An
Bord
Pleanála

Inspector's Report ABP-311137-21

Question	Whether the construction of an agricultural structure is or is not development or is or is not exempted development
Location	Ballyreagh, Enniskerry, Co. Wicklow, A98 HV02
Declaration	
Planning Authority	Wicklow County Council
Planning Authority Reg. Ref.	EX 38/2021
Applicant for Declaration	William and Susan Allen
Planning Authority Decision	Is not exempted development
Referral	
Referred by	William and Susan Allen
Owner/ Occupier	William and Susan Allen
Observer(s)	None
Date of Site Inspection	8 th February 2022
Inspector	Ian Boyle

Drawn By:	Date:
Issue:	23-09-2021
Revision:	
Scale:	1:100 & 1:200 @ A3 SIZE
Drawing No.	A-2

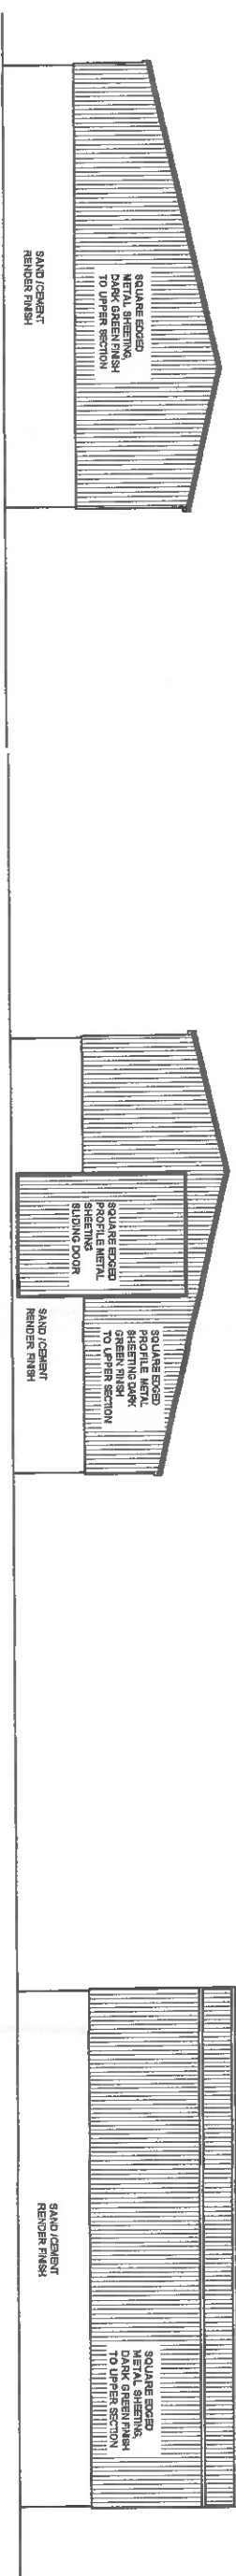
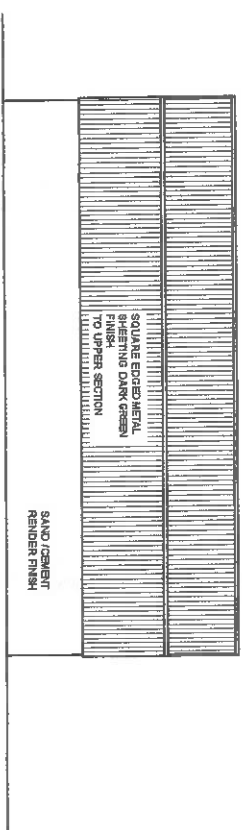
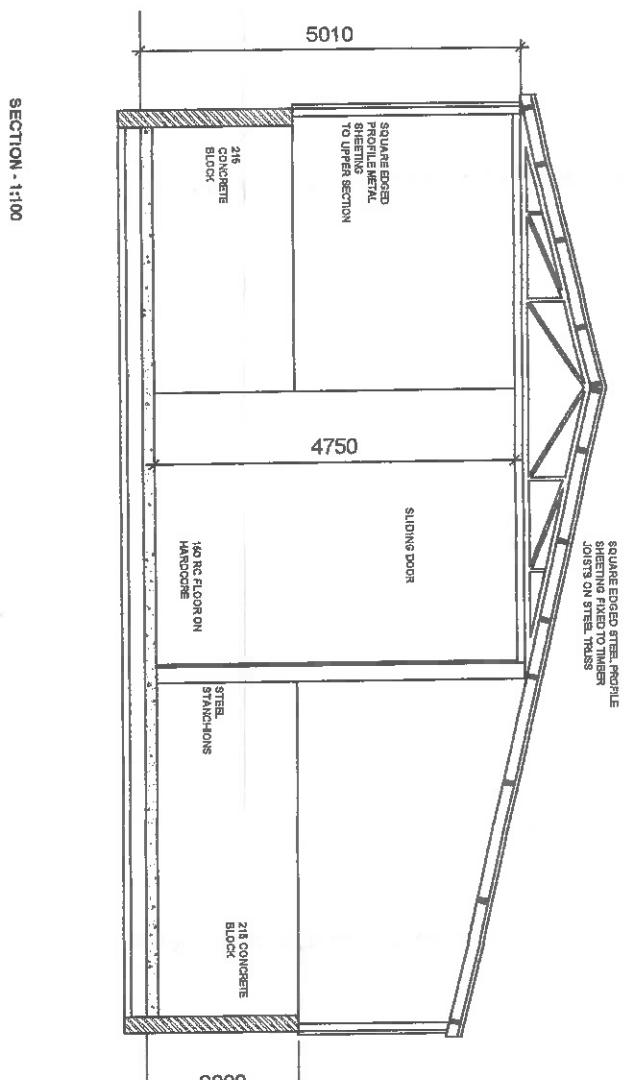
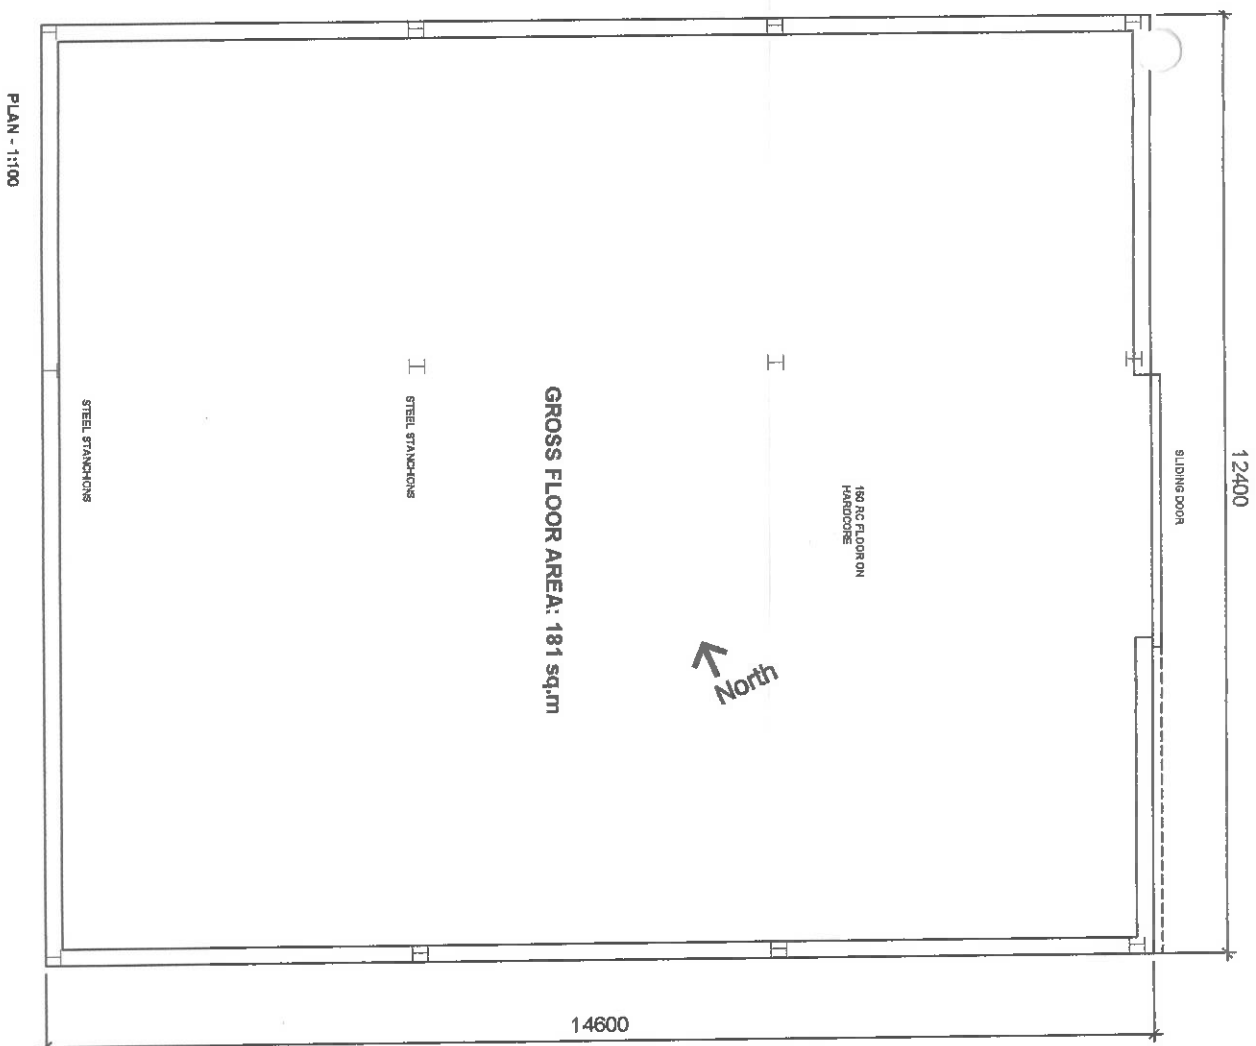
- 1.3. The proposed building would be approximately 12.4m by 14.6m giving an overall area of approximately 181sqm. It would have a height of 5m to eaves level (6.4m at top of parapet) and be supported on steel stanchions.

- 1.4. The predominant external materials would be metal sheeting in a painted dark green finish for the upper section of the building with sand and cement render at lower level. The eastern elevation has a metal sheet sliding door for access.

- 8.2.9. With reference to limitation 3, the agricultural building would not be within 10m of a public road. Therefore, limitation 3 is complied with.
- 8.2.10. With reference to limitation 4, the agricultural building would not exceed 8m in height, as it would have an overall height of 6.4m. Therefore, limitation 4 is complied with.

- 8.2.12. With reference to limitation 6, the regulations state that 'no unpainted metal sheeting shall be used for roofing or on the external finish of the structure'. The external treatment of the proposed structure would be metal sheeting painted in a dark green finish for the upper section of the building, and a sand and cement render for the lower section. Therefore, limitation 6 is complied with.

8.4.5. Furthermore, I note that the proposed external treatment is metal sheeting painted in a dark green finish for the upper section of the building, and a sand and cement render for the lower section, which I consider appropriate in this context considering the nature of the surrounding landscape.

Project:		Drawn By:	Date:
PROPOSED AGRICULTURAL BUILDING AT BALLYREAGH		Issue:	10-8-2021
Title:		Revision:	
SITE LAYOUT		Scale:	1:1,000 @ A3
		Drawing No:	A-1

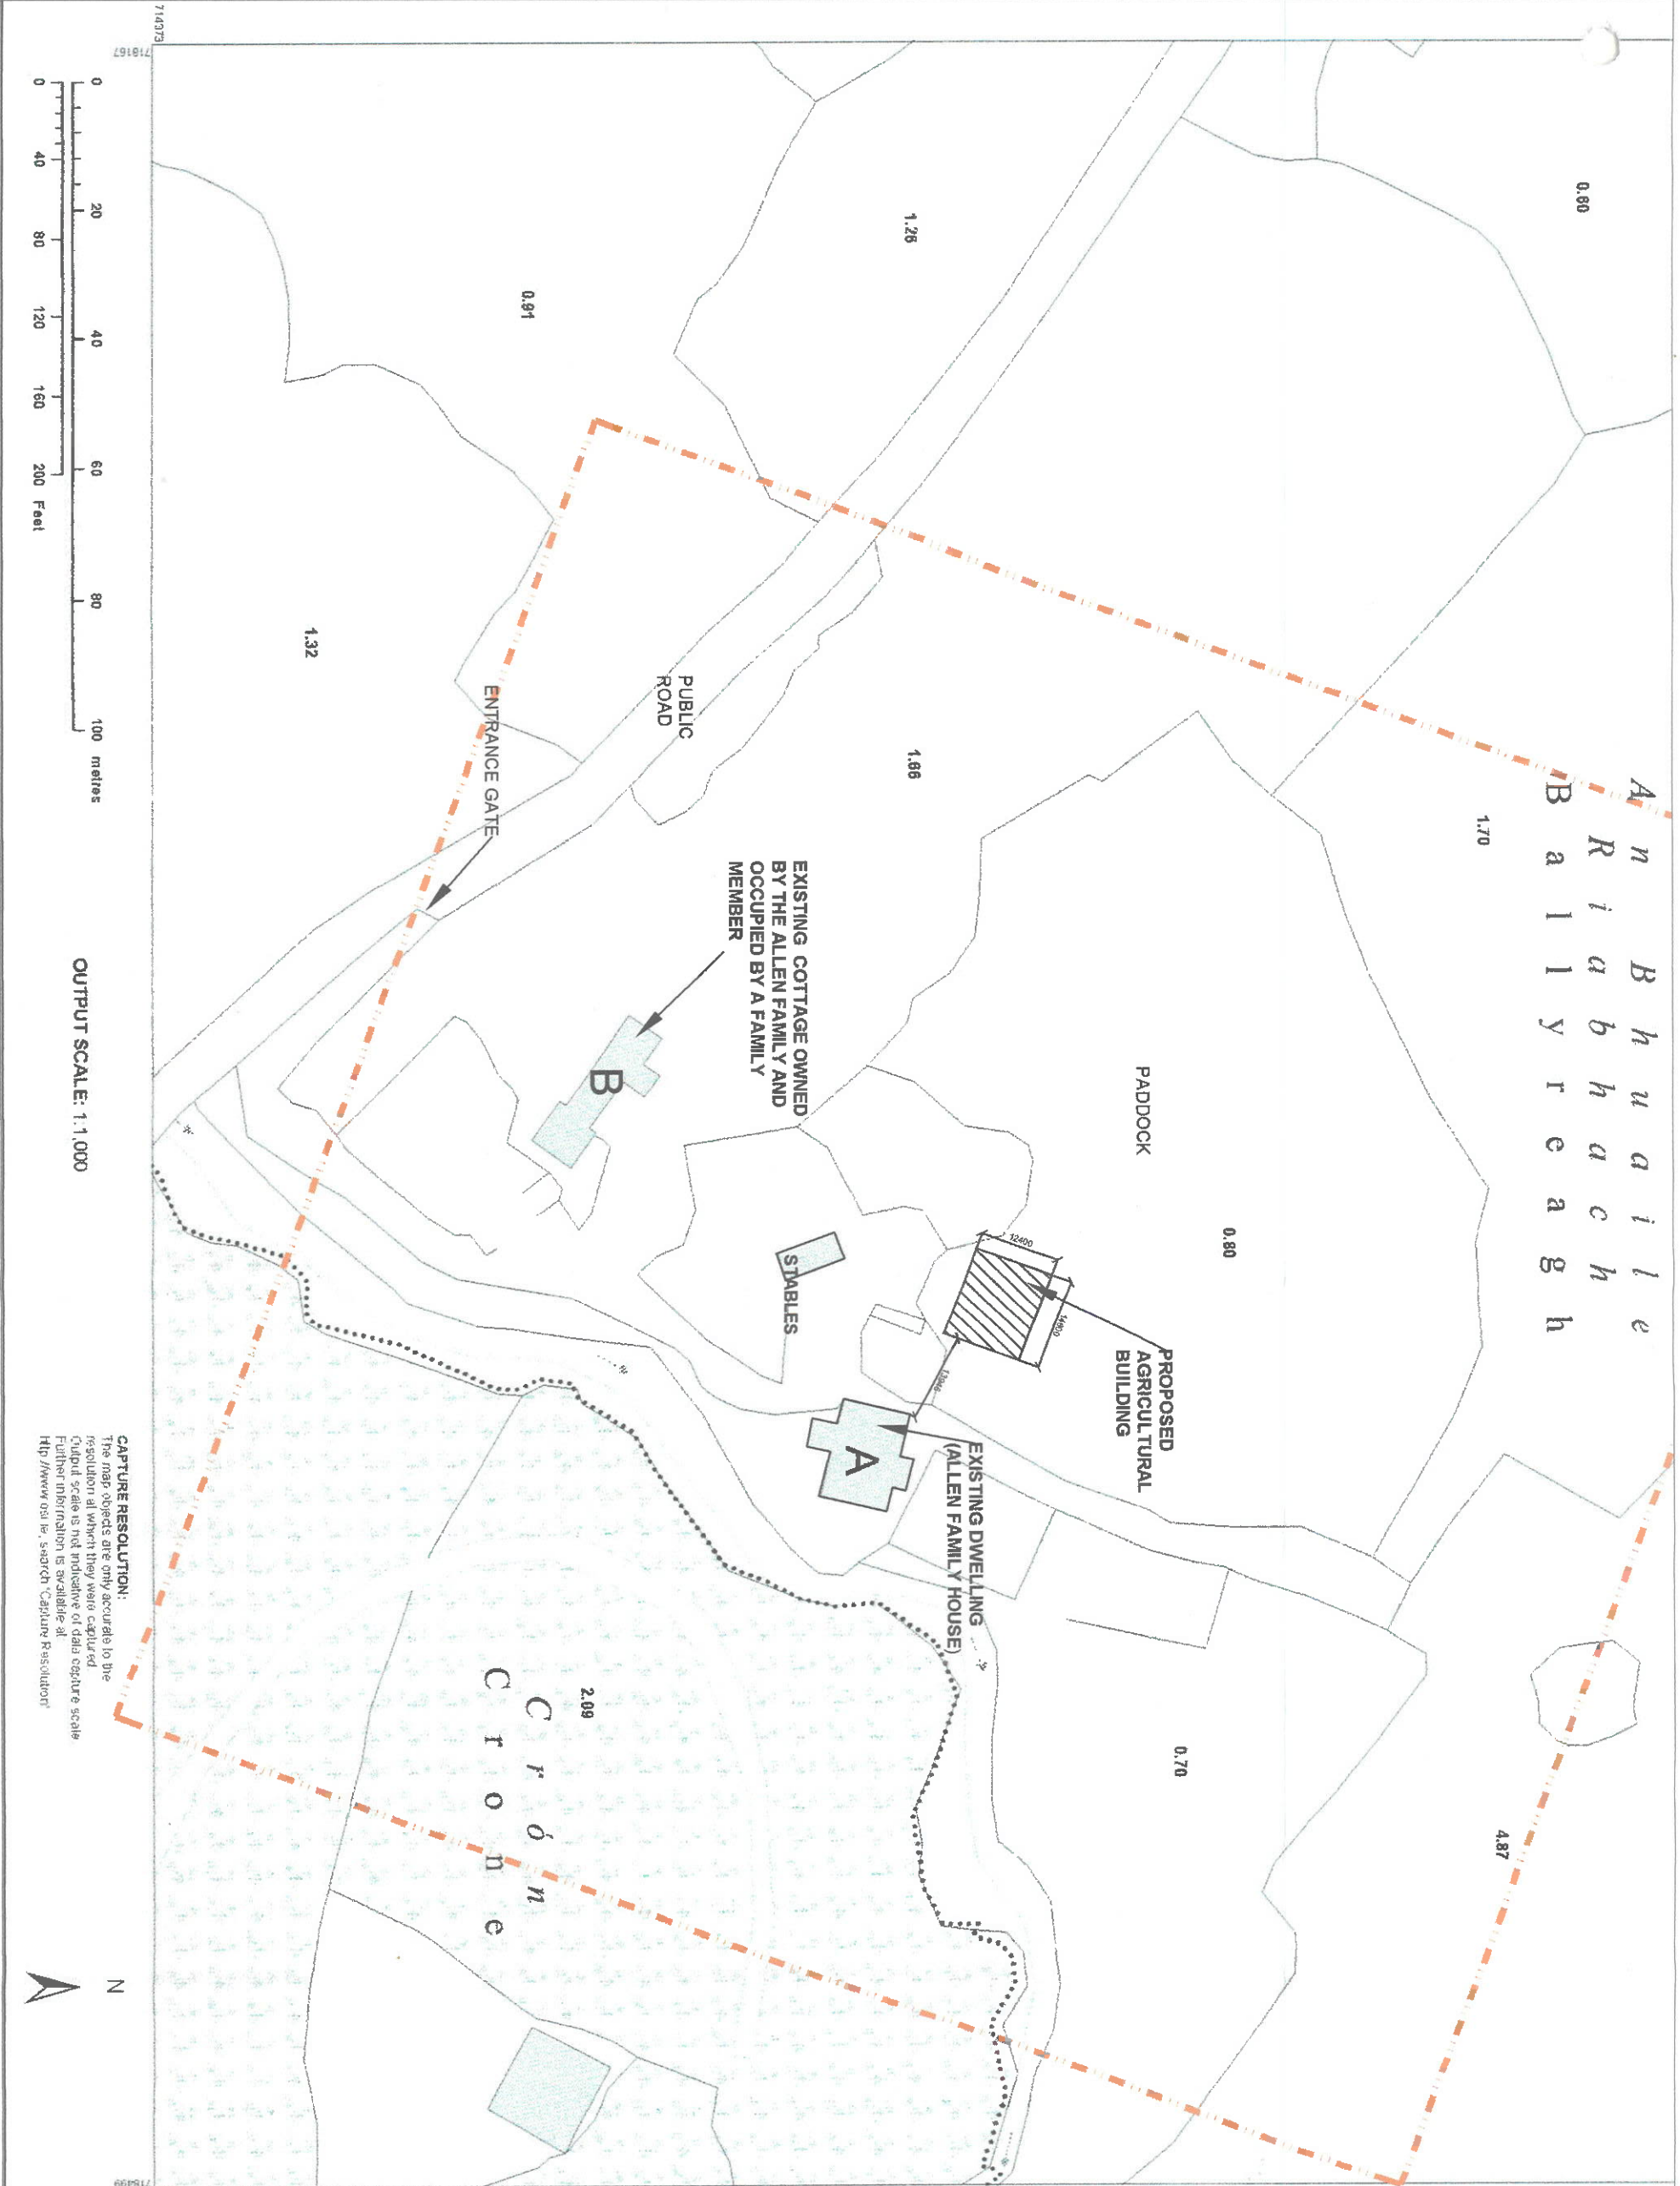
- 1.2. The proposed agricultural building would be situated approximately 14m west of an existing dwelling, which is denoted as 'Existing Dwelling (Allen Family House)' on the submitted drawings, and 57m north of a further house, which is also within their ownership. There is a small outbuilding directly to the south of where the agricultural structure would be situated and there are extensive tree stands, sporadic forested areas, and vegetation in each direction. The landscape is undulating and characterised by large tracts of forested land.

- 8.2.11. With reference to limitation 5, the agricultural building would not be located within 100m of any house, or any other residential building or school, hospital, church or building used for public assembly, that is not within the Applicant's ownership. The Applicant has stated in their appeal submission that they are the owners of the land, and the dwellings that are on it, including those within the 100m buffer zone. Therefore, limitation 5 is complied with.

- 8.4.2. The proposed agricultural barn is on a low -lying part of the site and, therefore, is not on or near a ridgeline or in an elevated position that might be deemed visually prominent.

- 8.5.5. I note that a tributary of the Glencree River is roughly 40m to the east of the location where the proposed development would be situated. The tributary runs in a general southwest - northeast direction, away from the Wicklow Mountains (SAC and SPA), which are to the west and southwest, respectively. There is no direct hydrological connection to any downstream European Site, however.

- 8.5.6. The land on which the proposed development would be situated is on lower ground than the adjacent tributary. I note also that the internal access road leading from the public road to the houses, which are further north, would run between the location of the proposed structure and the stream.
